**Consultation Response from KC,
Highways Development Management****2024/90256 Whitehall Service Station, Whitehall Road East, Birkenshaw, BD11 2EJ****Change of use from coin operated jet wash to attended hand car wash****Date Responded: 24-7-2024.****Responding Officer: Mark Berry.****Responding Ref: 8-10NE-10.**

Site Location Plan (1:500)

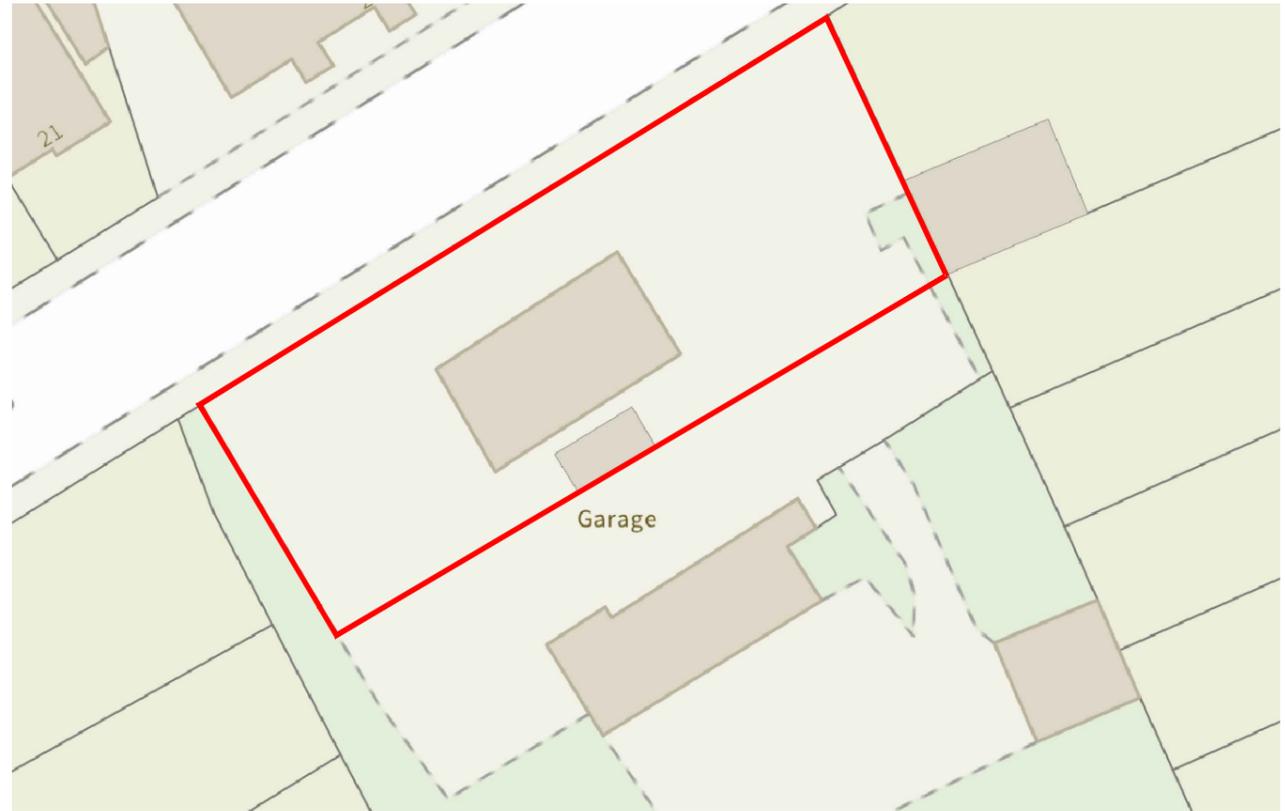
The proposals show 4 bays on the western side of the site (2 wash bays and 2 dry bays) and small building for staff facilities and on the eastern side. 3 off-street parking spaces are shown to be provided in front of the proposed staff facilities building for waiting customers.

The entrance and exit are not signed or managed in any way and there is no circulation route for vehicles to follow through the site.

There is very little stacking space for vehicles waiting at busy times just 3 off-street parking spaces. This could potentially result in vehicles queuing out of the site across the footway and onto Whitehall Road.

Vehicle movements into and out of all the proposed parking spaces and wash bays will conflict with vehicles entering and exiting the motor repair garage, petrol pumps and shop.

HDM consider that this proposal will result in the over-development of the site resulting in too many vehicle conflicts and vehicles potentially queuing out onto Whitehall Road which would not be in the best interests of highway safety.
